Town & Country Planning (Control of Advertisement) (England) Regulations 2007 (as amended)

Application No: CM/3/22/A
Site Address: Maidenhead Aquatics Crookthorn Lane Climping BN17 5SN
Description of works: Installation of 1 x internally illuminated fascia sign.

OWPC44478

DRAWING TITLE
As-Existing Elevations with Sign 1 Details

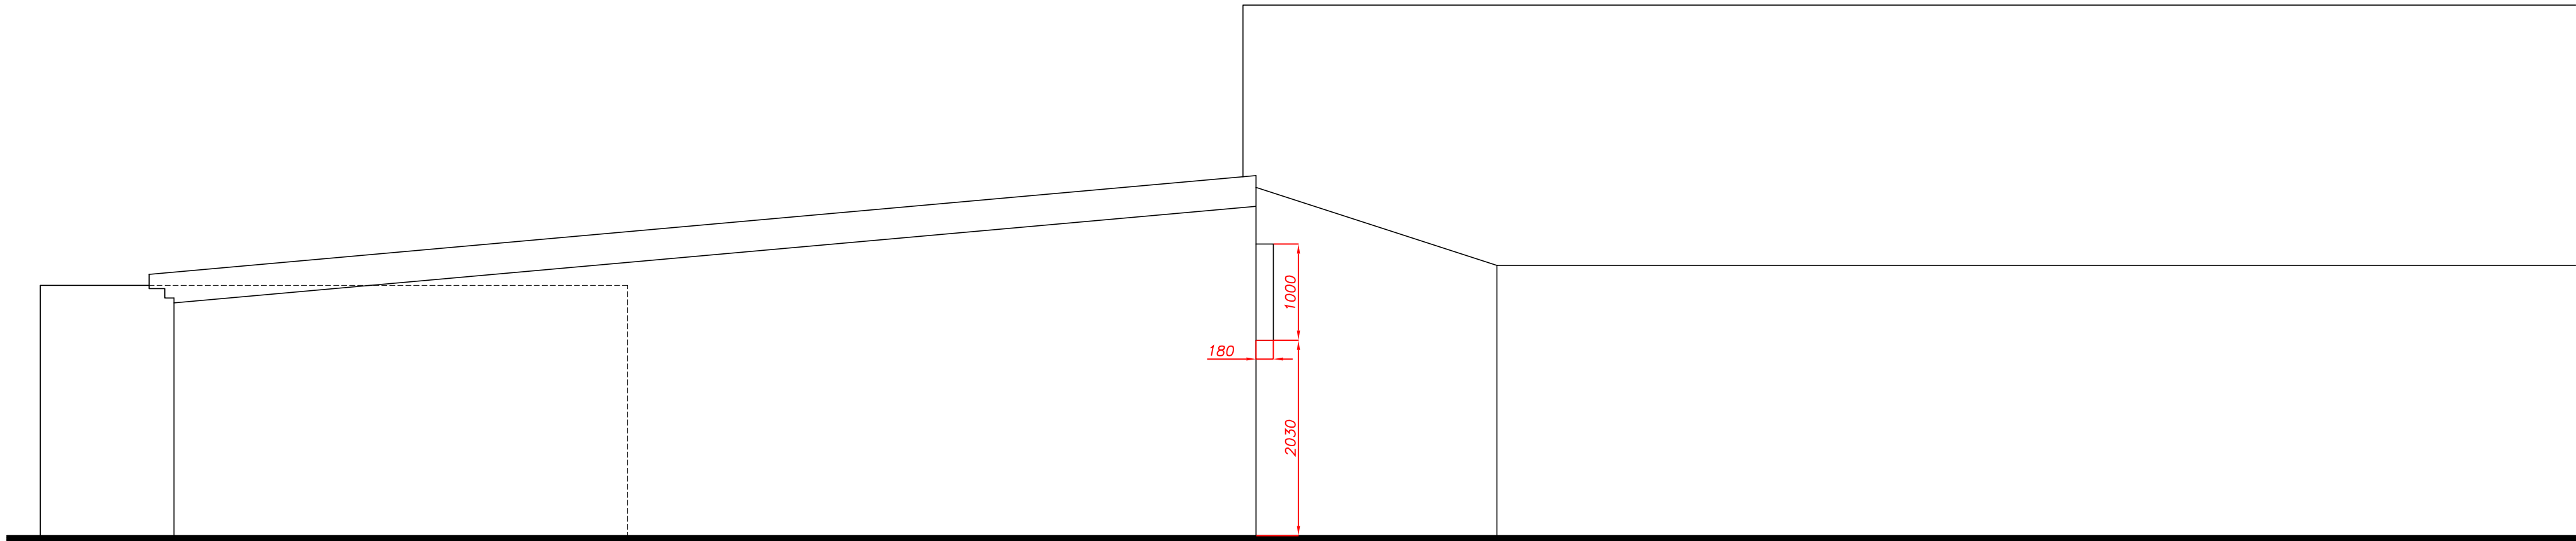
Clympling Parish Council strongly objects to this application on the basis that a proposal for illuminated fascia signs at this site is inappropriate illumination and totally out of keeping with the character of the area and will intrude on a rural area.

The proposal is contrary to policies CPN4 & CPN11 of the Clympling Neighbourhood Plan. The illuminated signs will impact on the amenities enjoyed by occupants of surrounding properties and does not integrate with the local built environment and landscape context as described in the Clympling Character Assessment. It should also be considered that as the site is within a rural area, such lighting could have an impact on wildlife.

Furthermore, in terms of highway safety, the proposal of four illuminated signs could confuse and distract drivers on A259.
